Date: 29th August 2012
To: Planning
Cc: -
From: Miriam Hill
Subject: S6/2012/1591/FP – Northaw C of E Primary School, Vineyards Road,
Northaw
Erection of mobile classroom unit

I have reviewed the proposal for the above site and refer to drawing number 8644/04.

Plan of Proposed Mobile Classroom Unit

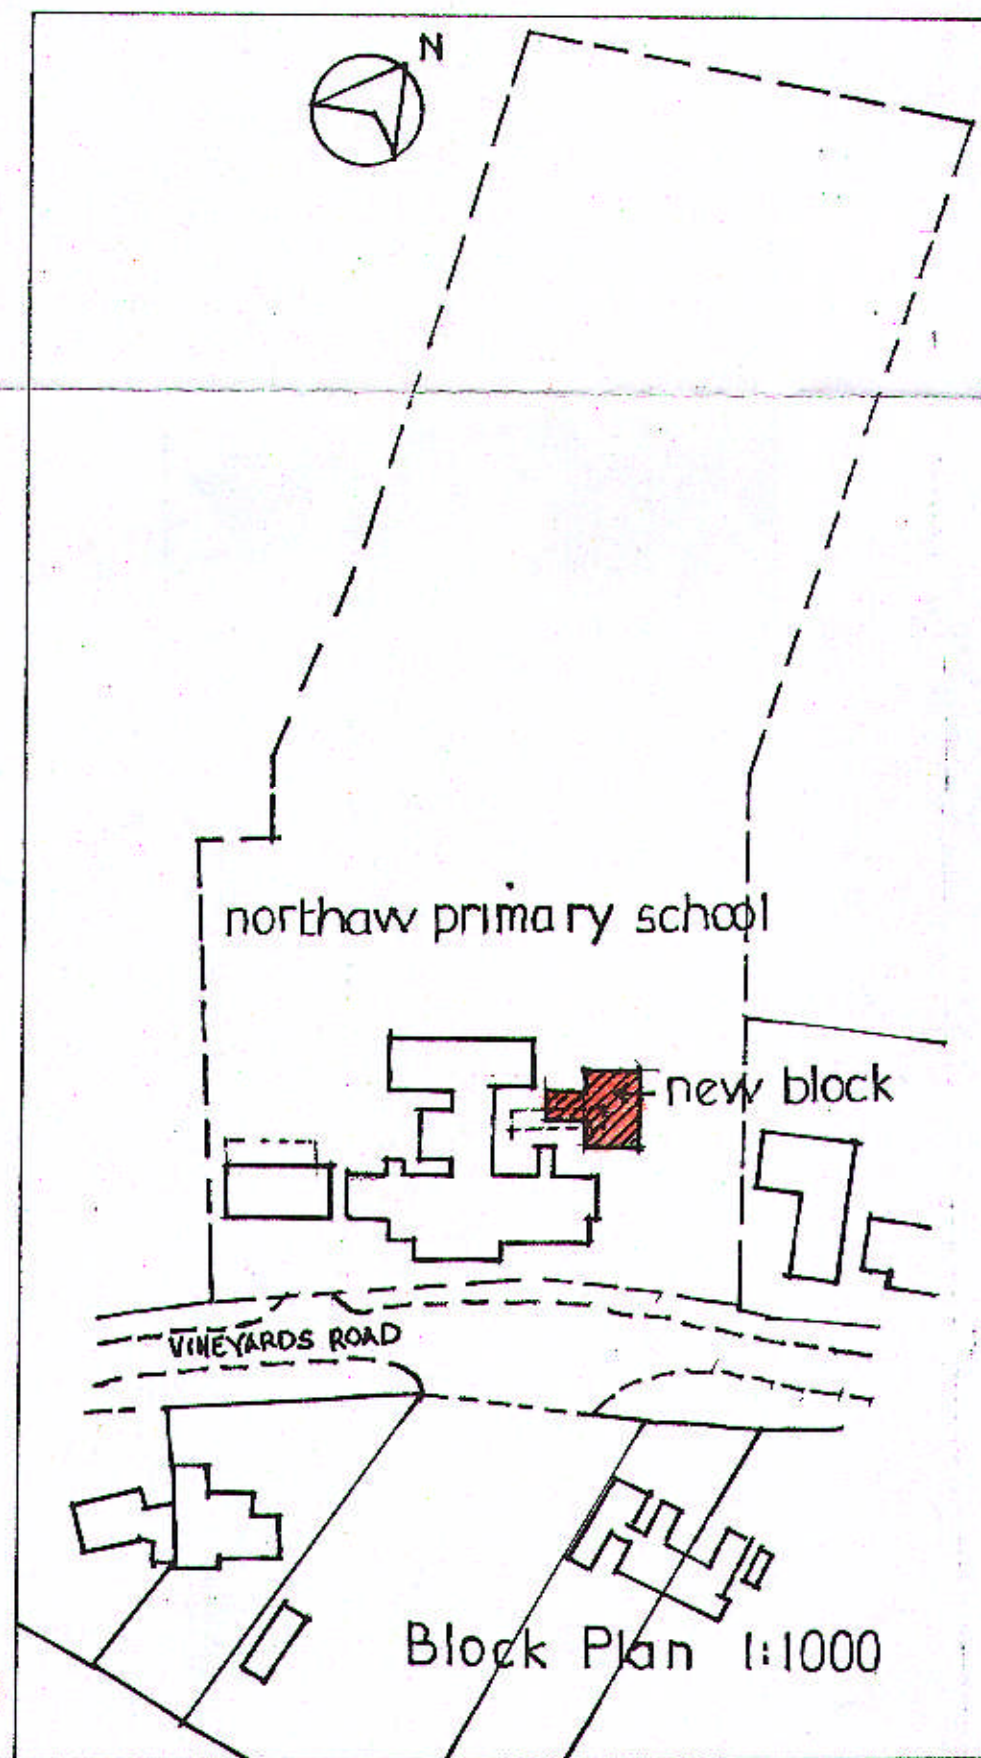
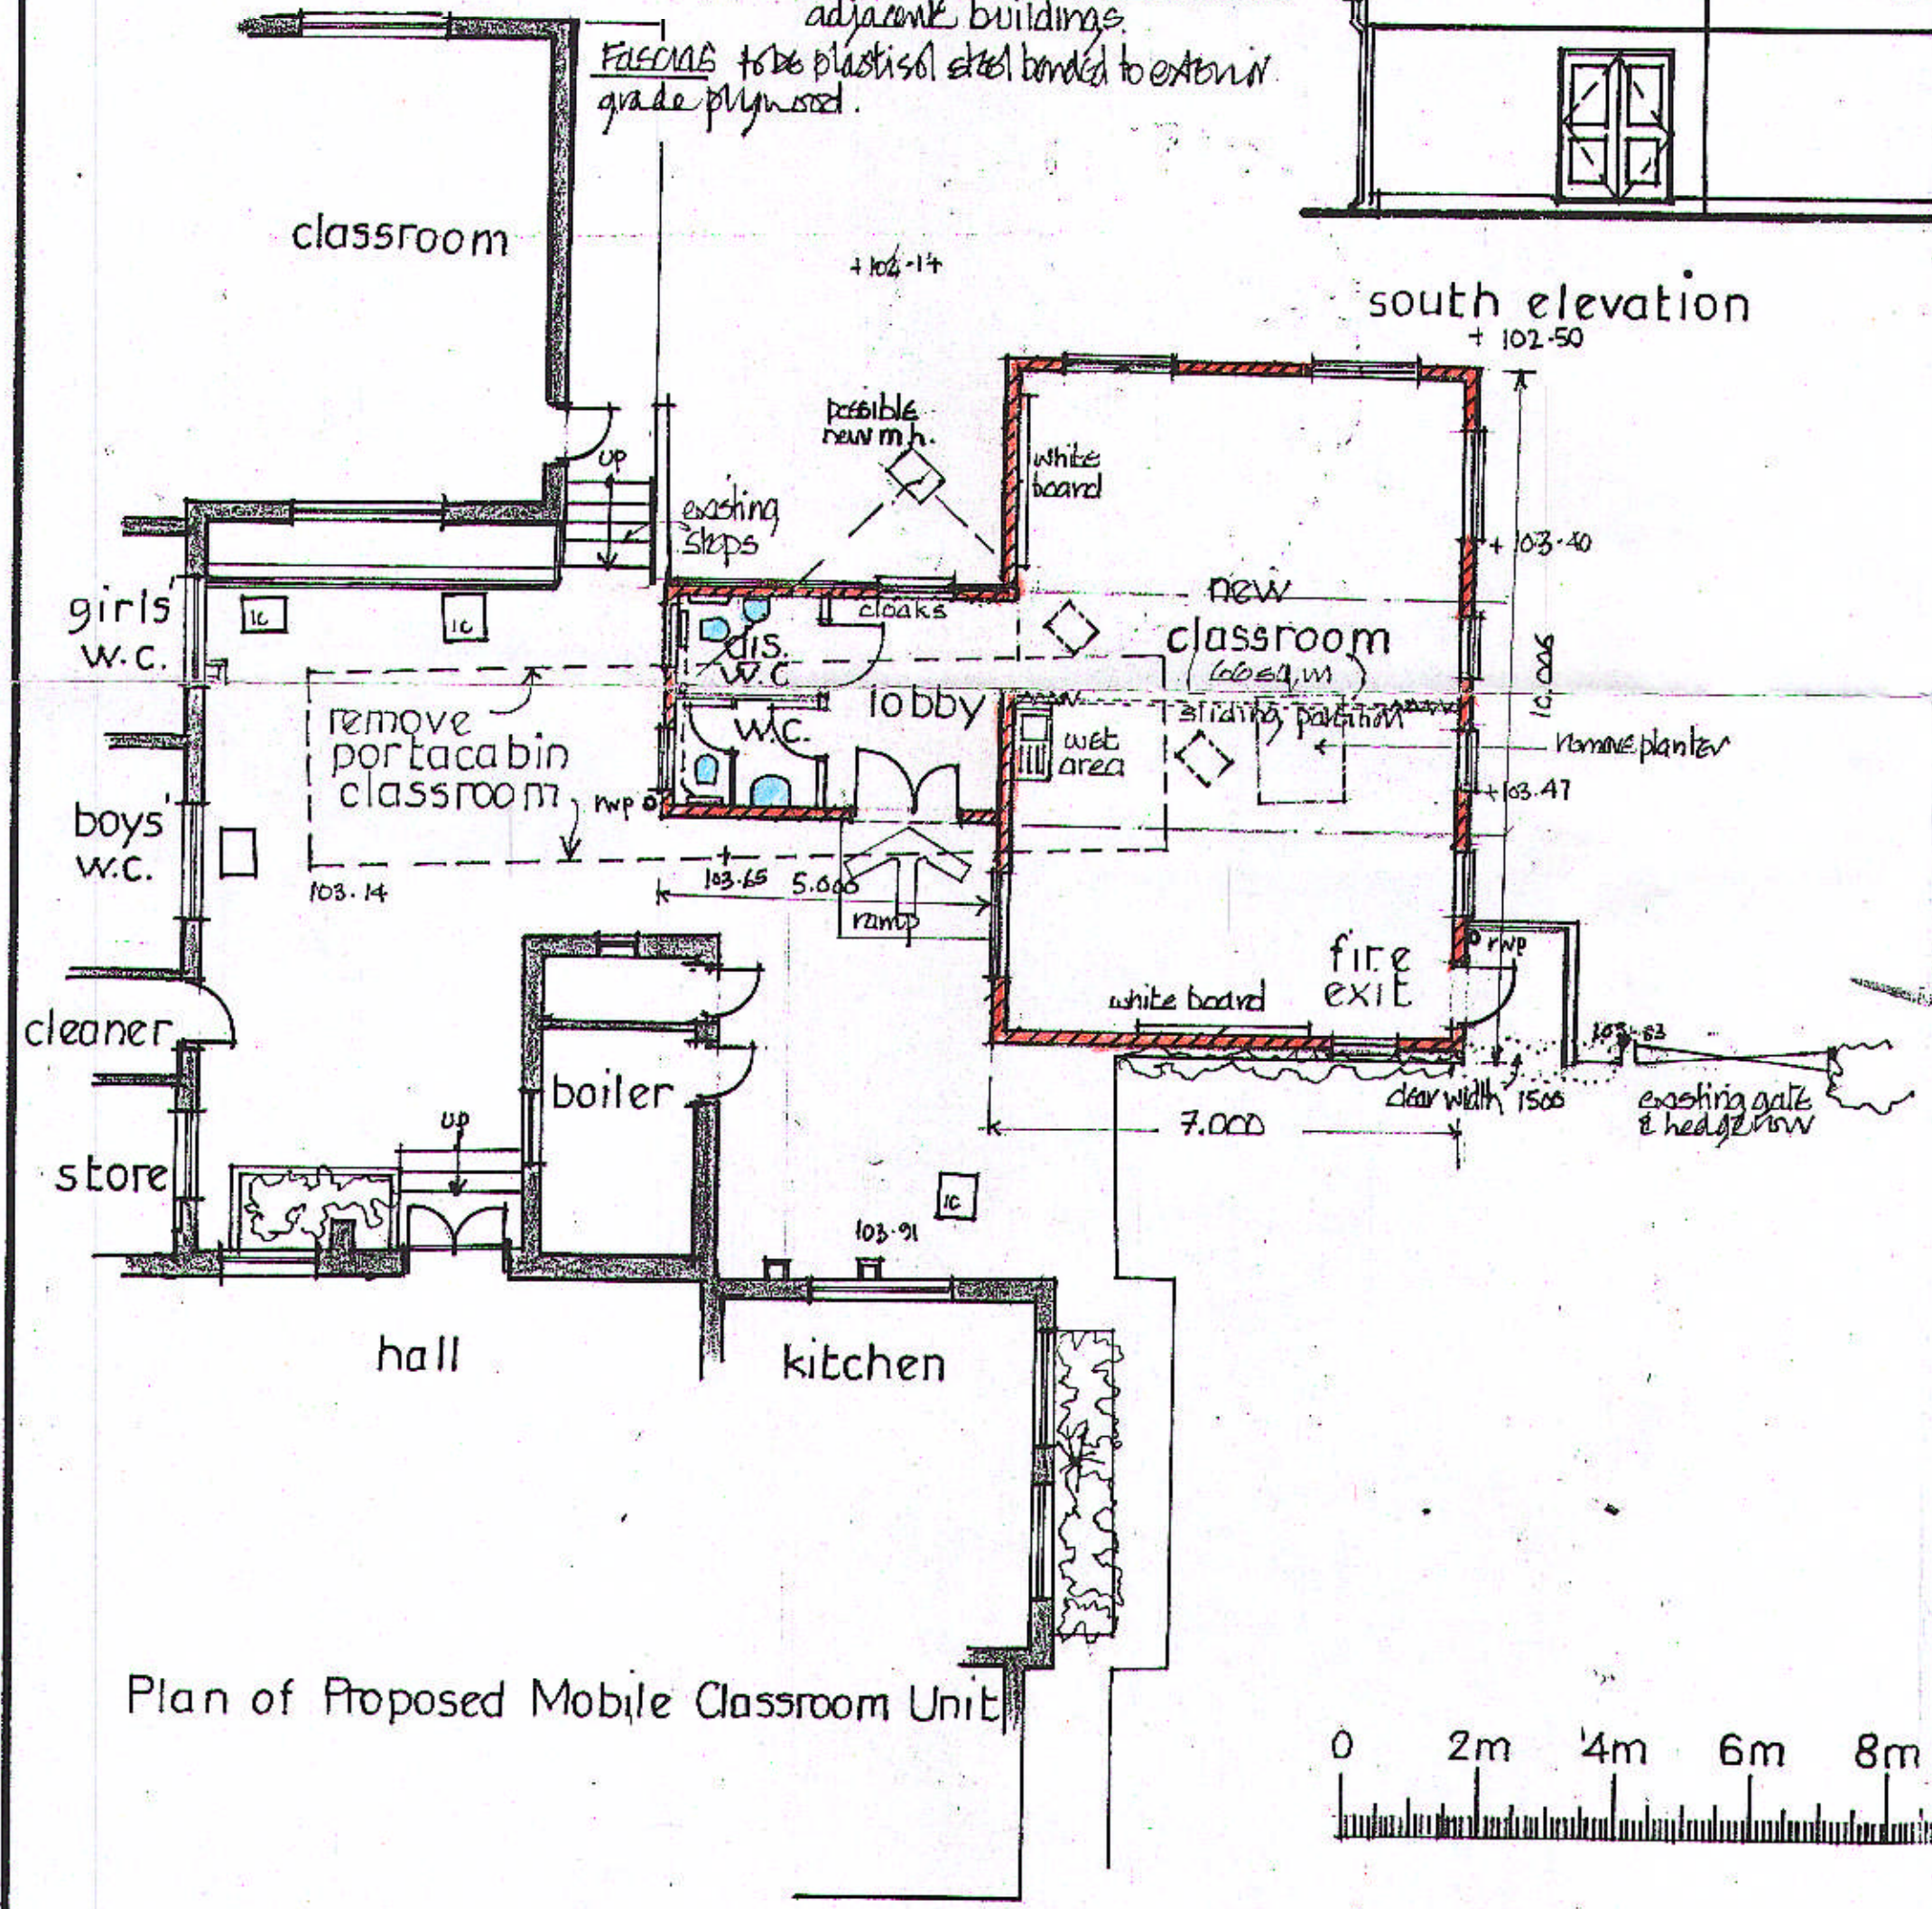
There are several trees within the grounds, the most notable one close to the proposed block is a weeping willow. The tree should be of sufficient distance from the new block to remain unaffected.

The proposed block is partially hidden by the existing building from the west and south. A roadside and internal to the site hedge and a shrubbery act as partial screening from the south east. As the bulk of the building will be screened from the road it is not necessary to suggest more landscaping for this site.

Overall I have no objections to this application. I hope that these comments are clear and that if you need anything further then please contact me.
